Reference: OR-0008353/01

Customer reference: EN0110012

**ENVIRONMENT AGENCY RESPONSE TO FURTHER INFORMATION OR SUBMISSIONS
ACCEPTED BY THE EXAMINING AUTHORITY. LIGHT VALLEY SOLAR.**

Figure 15.10

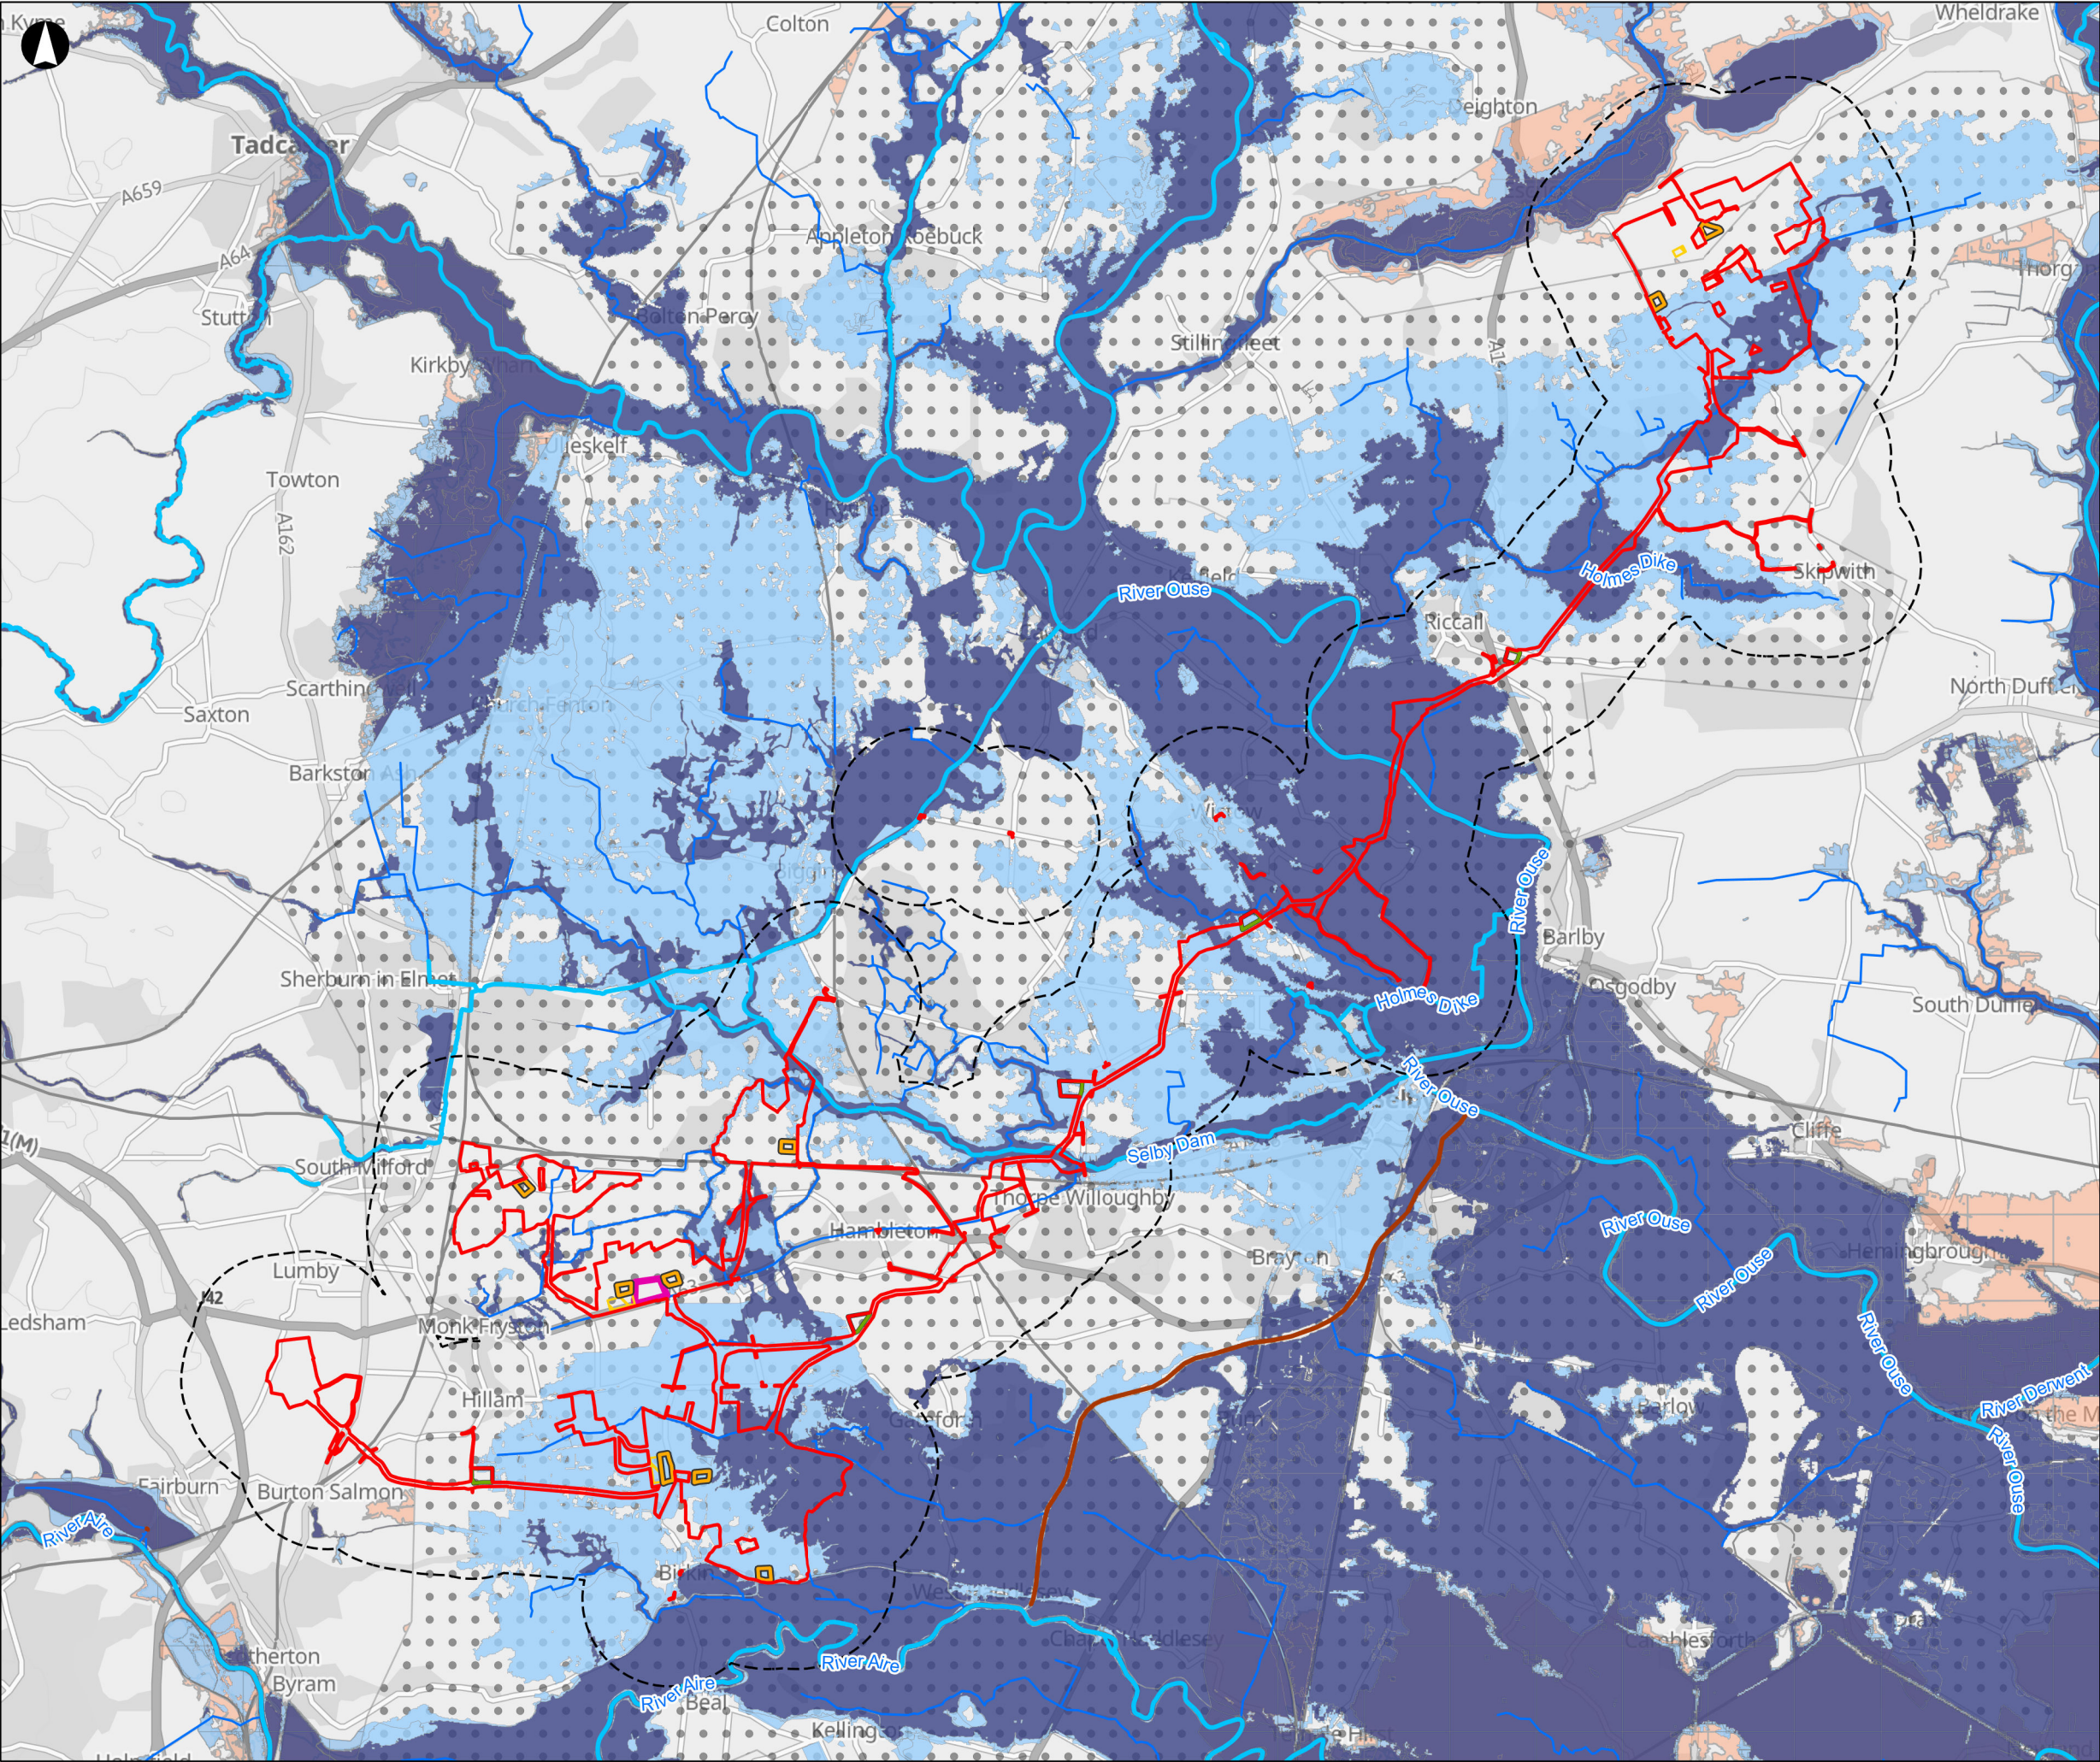
Having reviewed Figure 15.10 Risk of Flooding from Rivers and Seas [\[PDA-011\]](#), we have no comments to make on the extent of Flood Zones 2 and 3, under current conditions.

However, the Flood Zone mapping with climate change extent shown appears blocky and is not characteristic of a modelled flood outline. This is likely because detailed Flood Map for Planning climate change data is not available for this area. As such, the climate change outline presented does not appear to represent future fluvial flood risk based on detailed hydraulic modelling.

The Applicant has undertaken detailed hydraulic modelling of the River Aire, River Ouse, and several smaller Ordinary Watercourses within Site 1 and Site 2. This modelling incorporates an appropriate climate change allowance in line with the vulnerability classification of the development. We have reviewed this modelling and all comments previously raised have been satisfactorily addressed. We therefore consider the models suitable for assessing flood risk associated with the proposed development. On this basis, the presentation of the climate change flood extent in Figure 15.10 does not affect the conclusions of the Applicant's Flood Risk Assessment, as the assessment is based on detailed site-specific hydraulic modelling rather than the Flood Map for Planning with climate change applied. We are therefore raising this point for awareness only, as other interested parties may make similar observations regarding the mapping presented. The Applicant may wish to consider adding a note to Figure 15.10 explaining the source and limitations of the climate change flood extent shown. However, from a technical perspective, we do not consider this absolutely necessary.

Figure 15.10 does not show the extent of Flood Zone 3b (Functional Floodplain). It should be noted that the Environment Agency's Flood Map for Planning does not distinguish between Flood Zone 3a and Flood Zone 3b. The delineation of Flood Zone 3b is ultimately a matter for the Local Planning Authority, although hydraulic modelling and other supporting evidence may be used to inform this determination.

Based on the Applicant's hydraulic modelling, all above-ground development associated with the River Aire and River Ouse is located outside the Functional Floodplain. The only element of the development located within the Functional Floodplain is the cable corridor crossing beneath the River Ouse.
